Your Ref BR/49/19/OUT

Our Ref: NW/ARU/19/08A

RE 26 Burnham Avenue Bognor Regis PO21 2JU

Thank you for your correspondence of 18th March 2019 regarding an 'Outline application with all matters reserved for 22No new dwellings consisting of 2No, 1 bedroom dwellings , 18No, 2 bed dwellings & 2No, 3 bed dwellings, for which you seek advice from a crime prevention viewpoint.

Second Floor Plan (Proposed) 1:100
2 x 2 bed Flats & 1 x 3 Bed Flats
x 2 Blocks

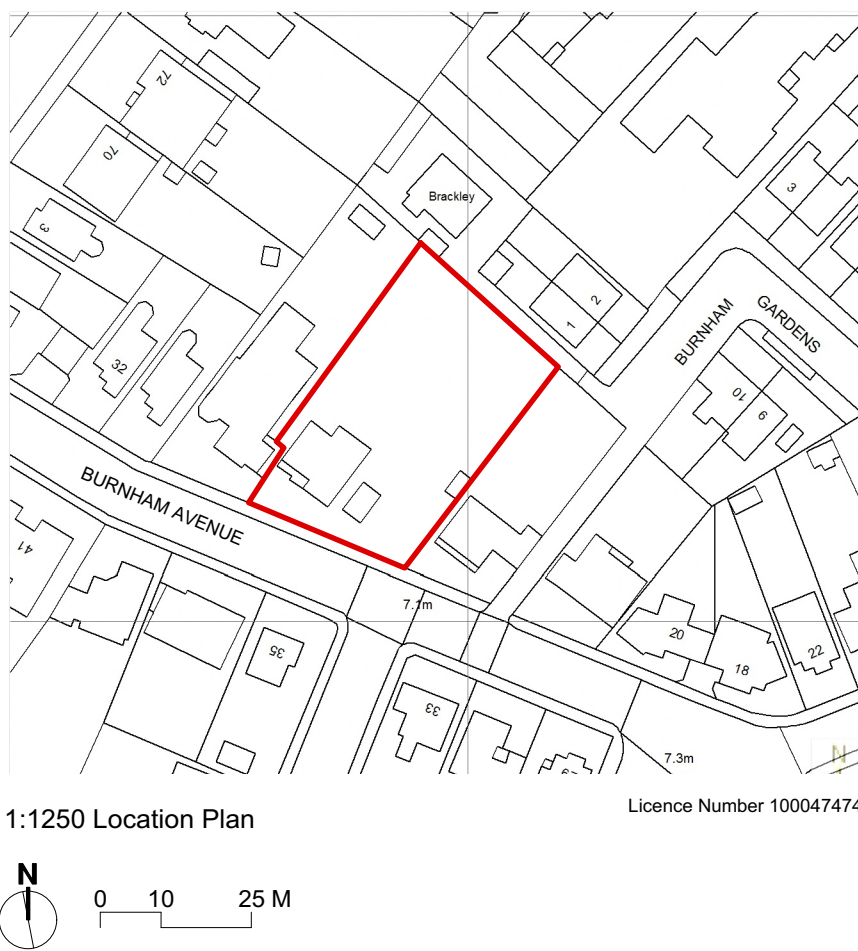
Laminated glass meeting the requirements of BS356:2000 class P1A is required for any window located within 400mm of a door set (to ensure the integrity of the locking system. Easily accessible emergency egress windows with non-locking hardware (a requirement of PAS24:2016) and easily accessible roof lights with non- locking hardware.

(Easily accessible is defined within Approved Document Q Appendix A as: a window or door set, any part of which is within 2 metres vertically of an accessible level surface such as a ground or basement level , or an access balcony . or A window within two metres vertically of a flat roof or sloping roof (with a pitch of less than 30 degrees) that is within 3.5 metres of ground level).

Roof / Site Plan (Proposed) 1:200

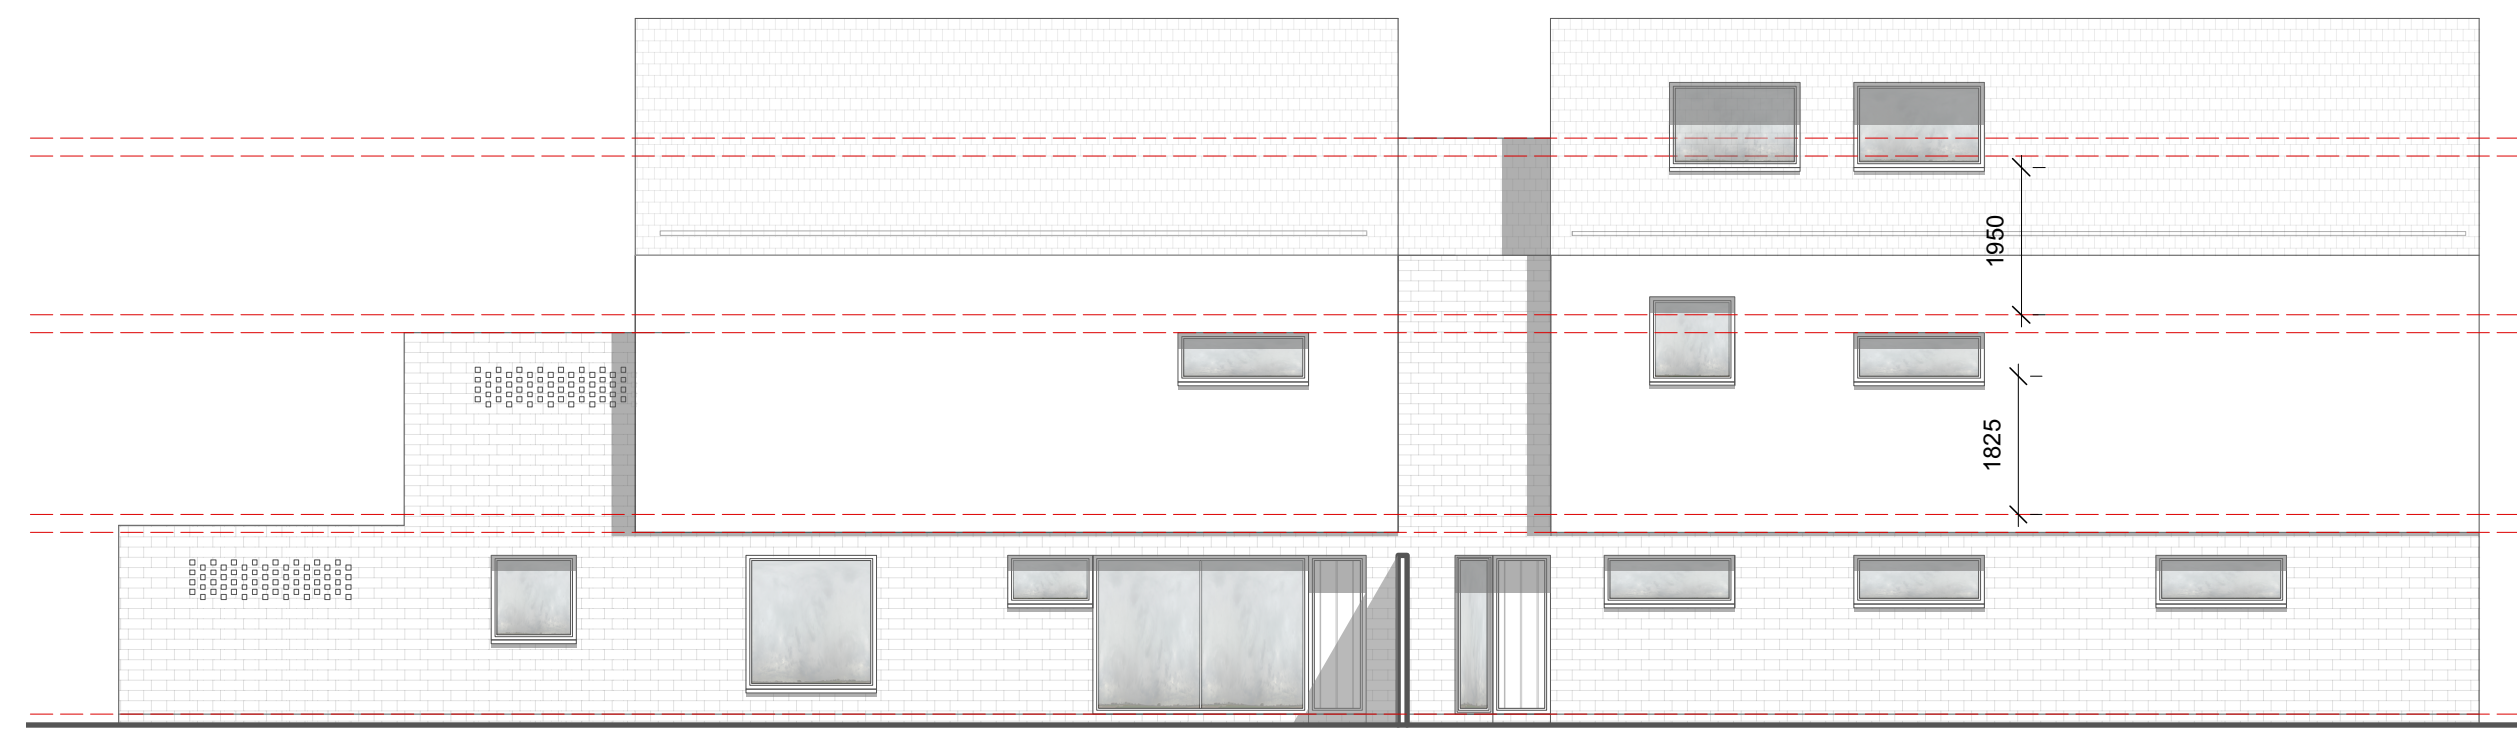
I note that there is no off street parking provision for the 22 dwellings. Although there are currently no parking restrictions in the road outside the application, there are many driveway entrances to other properties along its length which limits the space available to park in the road without blocking access to other properties. The location is also fairly close to Bognor Railway Station.

I am pleased to see a cycle storage provision. However there is no gated entrance to the development, which may allow unauthorised access to the proposed open cycle storage at the front. I would recommend that the cycle store is fully enclosed, with no windows and a controlled access door plus internal movement activated vandal resistant lighting and cycle stands or rack. I direct the applicant to Secured by Design Homes 2019 Chapter 56 and 57 for further recommendations. (The door locking system should have an internal lock release to prevent persons becoming accidentally locked into the store).
